Goulburn Mulwaree Council
Locked Bag 22
Goulburn NSW 2580

3 April 2025

**Subject: Modification 2 Gunlake Quarry Continuation Project – Mod 2 Trucks
(SSD-12469087-Mod 2)**

APPENDIX 3: PRIMARY AND SECONDARY TRANSPORT ROUTE

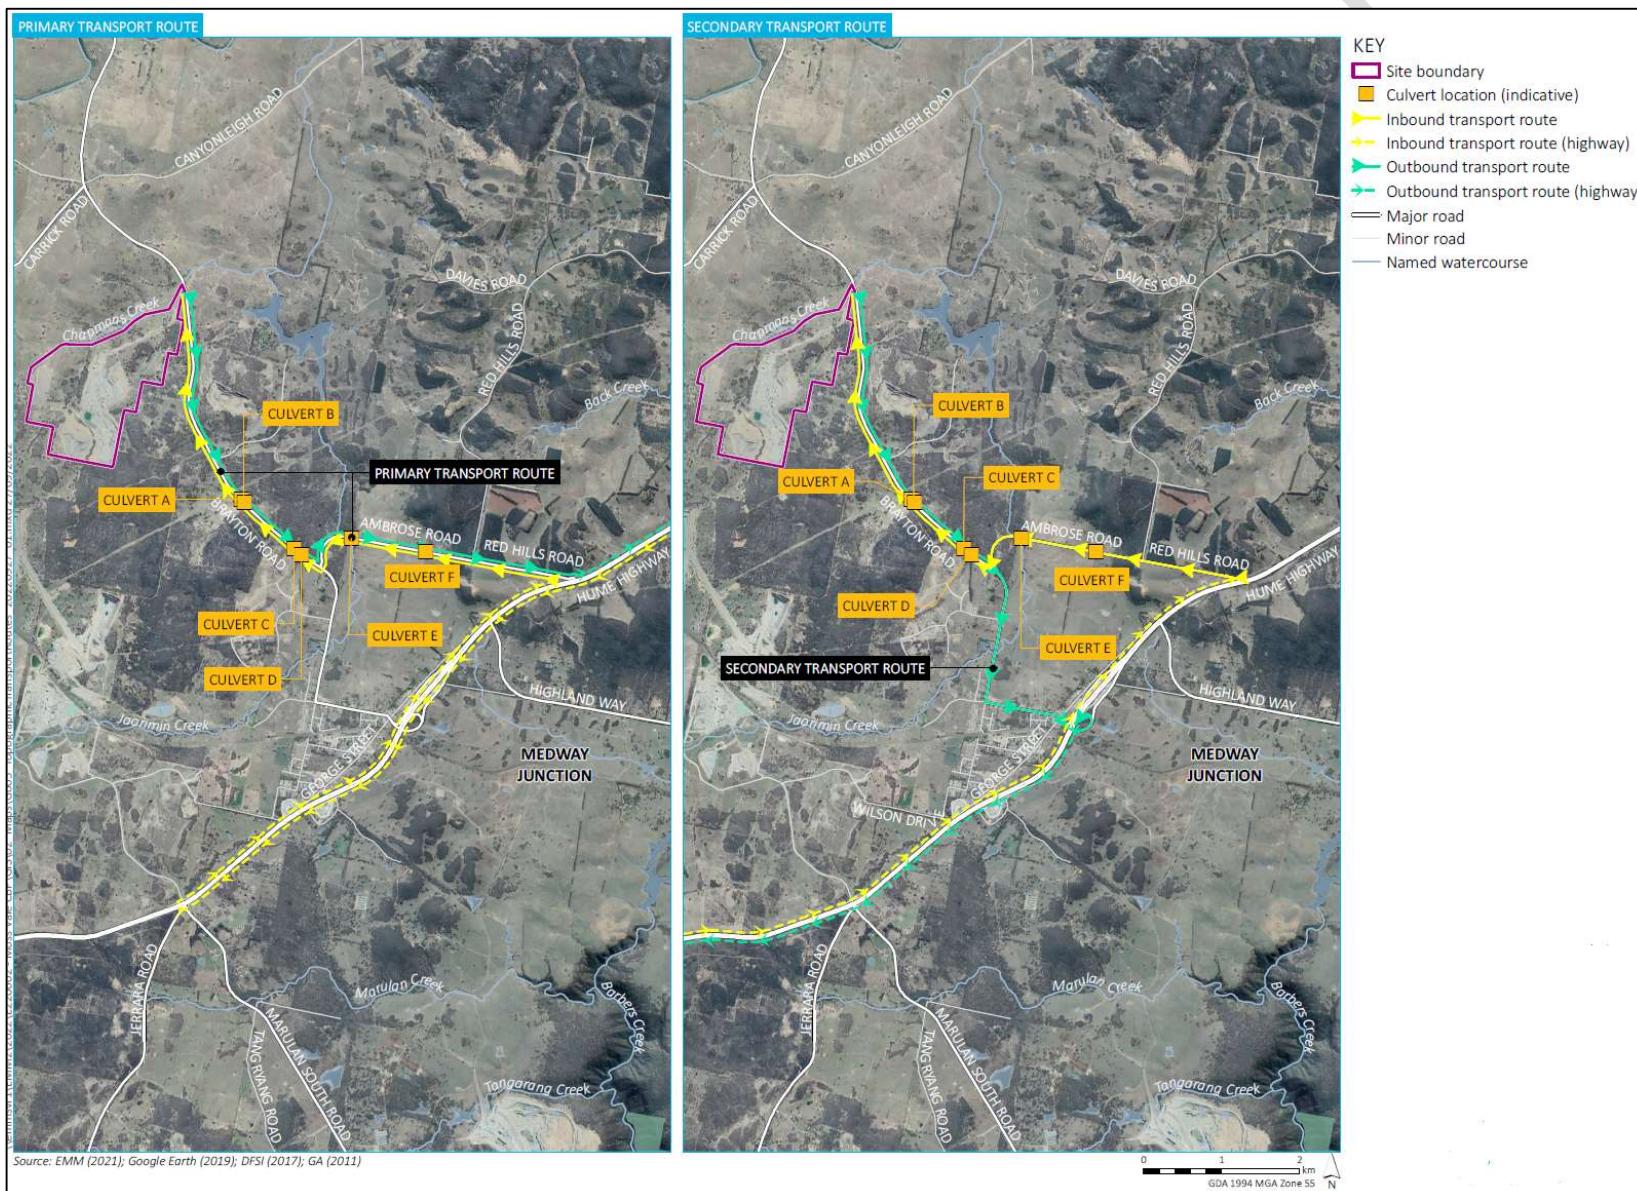
Note: The location of Culverts A-E is shown in Appendix 3.

It is noted that Council requested improvements to Culvert F on Ambrose Road but the applicant objected to this based on its Benefit/Cost ratio being excessive.

That the widening of Culvert F, as recommended in the report to Council of 19 July 2022, be included in the scope of works to be completed prior to commencement of the increase in truck movements.
